**Consultation Response from KC,
Trees**
2025/93271 1, Prince's View, Birkby, Huddersfield, HD2 2DE
Erection of car port to side
Date Responded: 10/12/2025
Responding Officer: JD
Responding Ref: 31/92

Proposed Site Plan
1 : 200

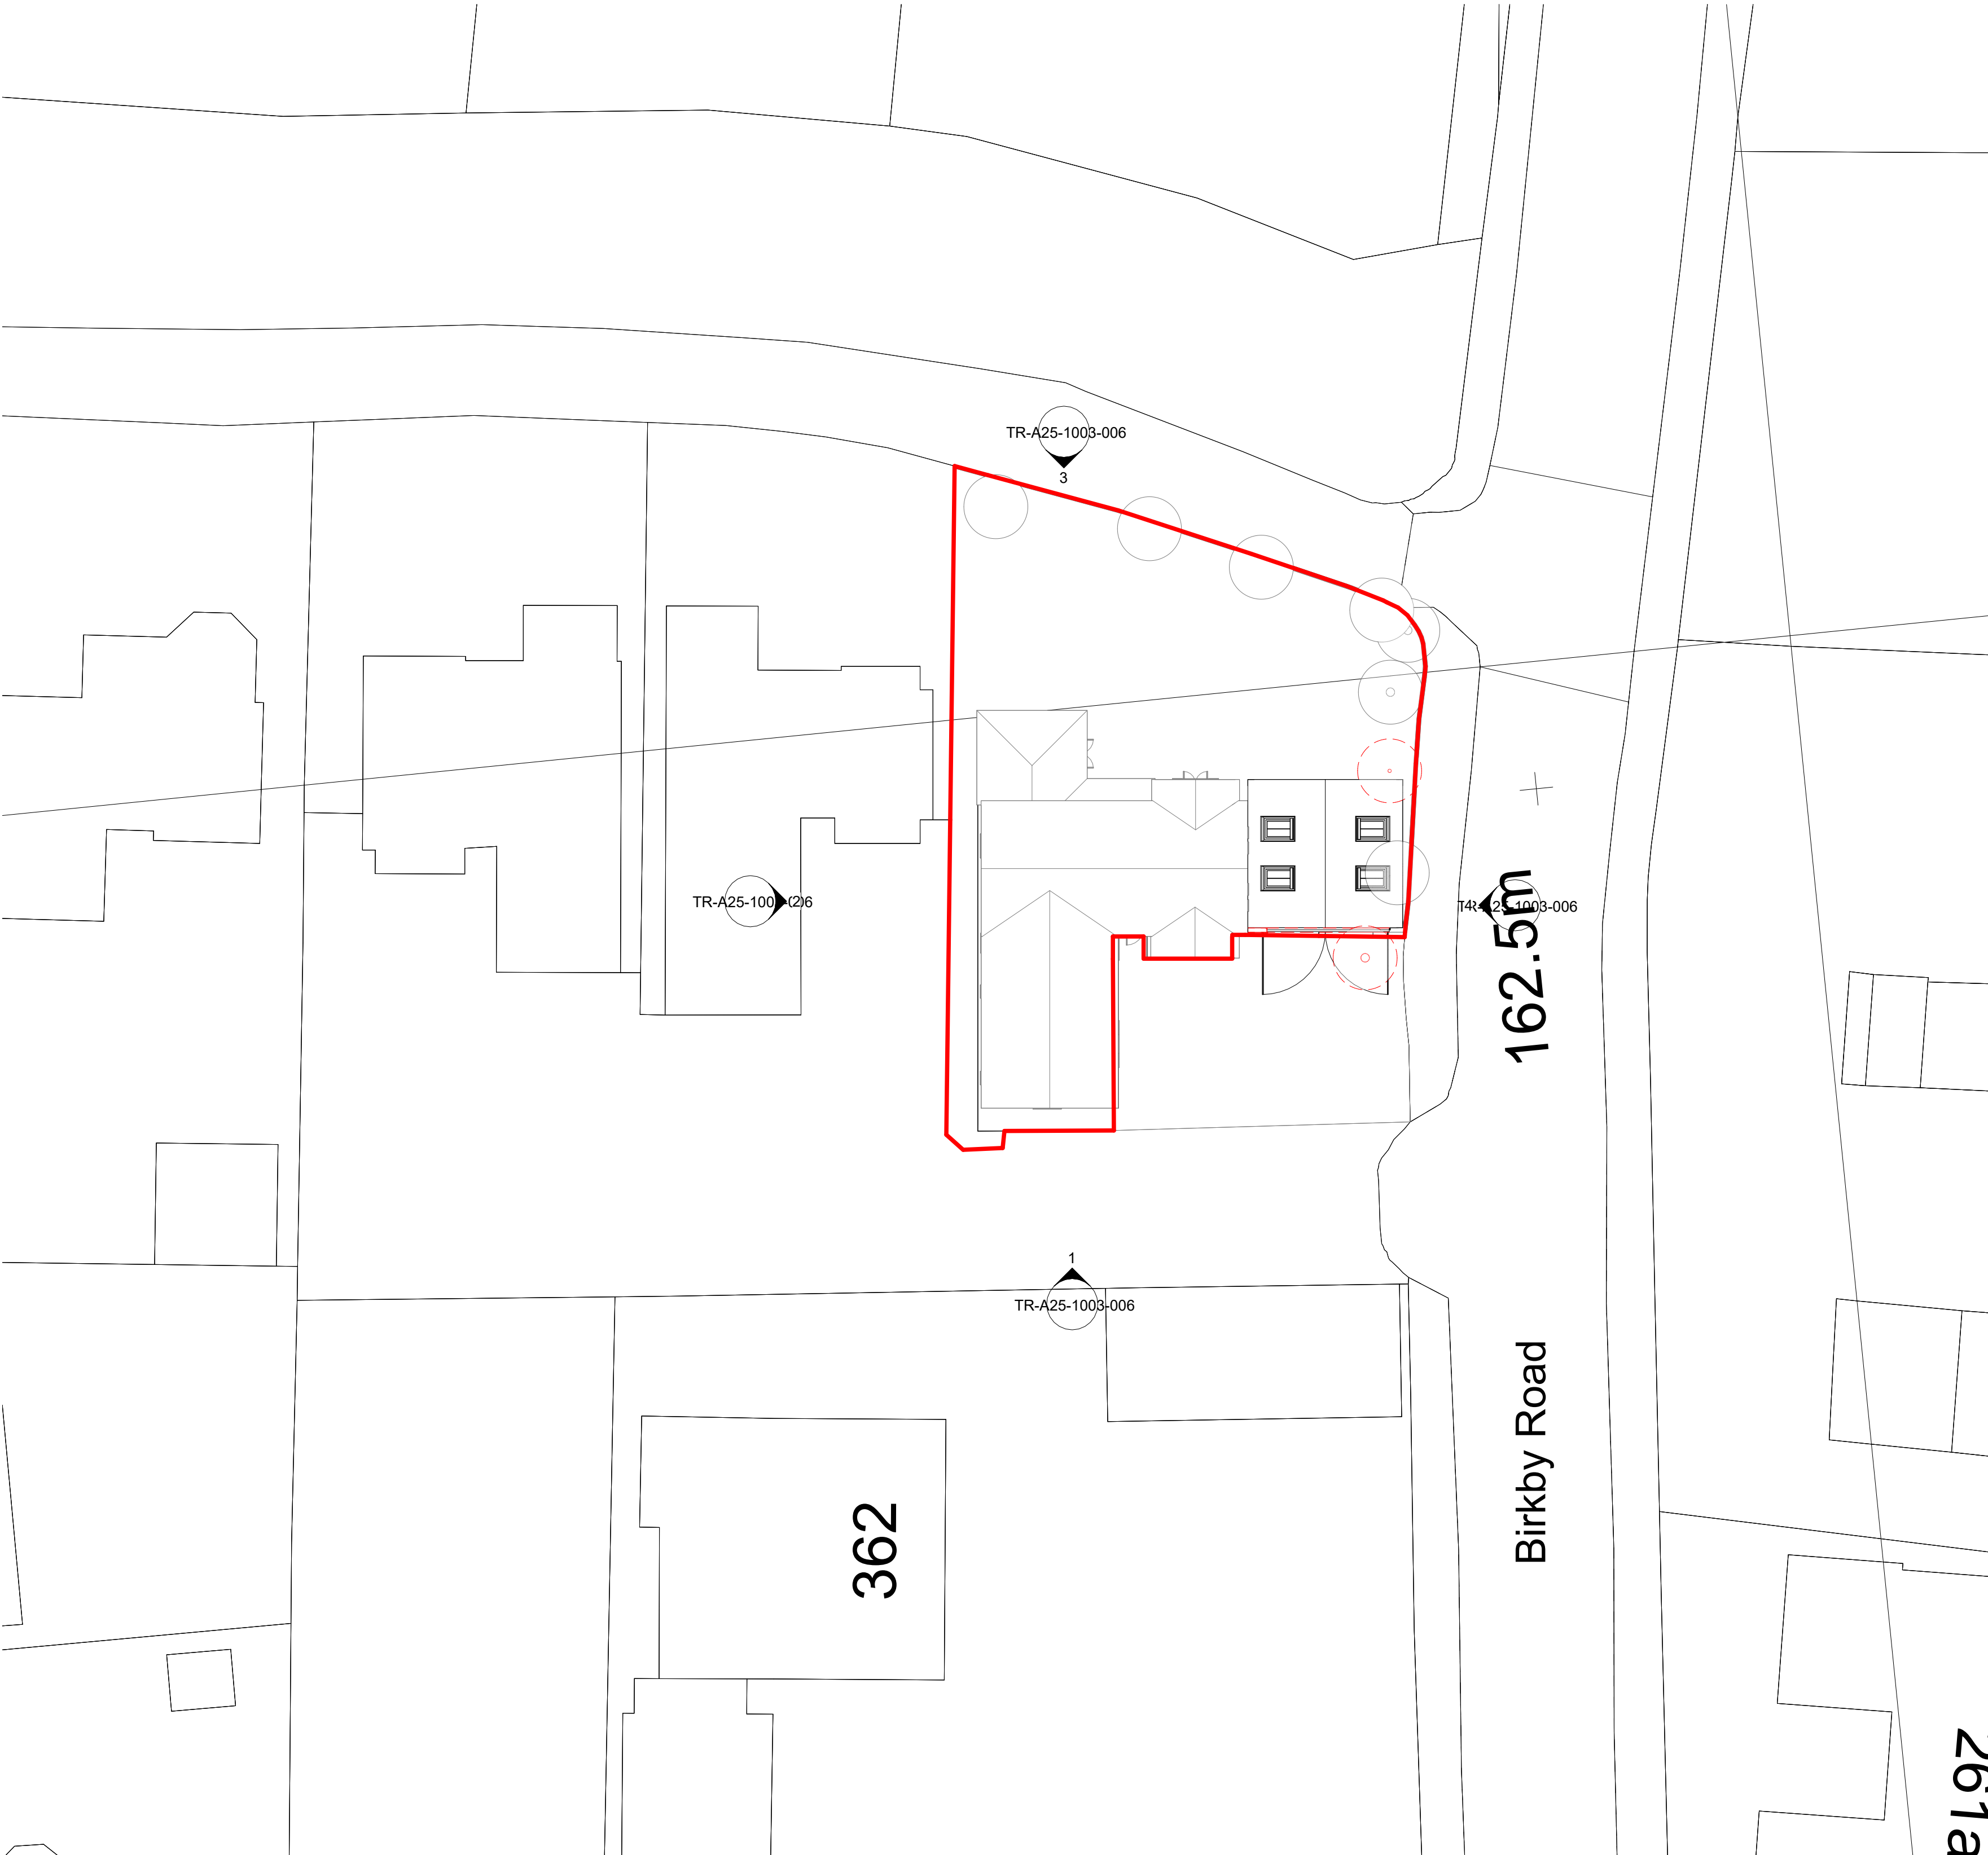
The submitted plans would require the removal of these protected trees and this would not be deemed acceptable due to the prominence of these trees and the associated amenity value they provide to the public.

There would be an objection to these plans from KC trees because the proposal conflicts with adopted Kirklees local plan policy 33 and 24 (i)
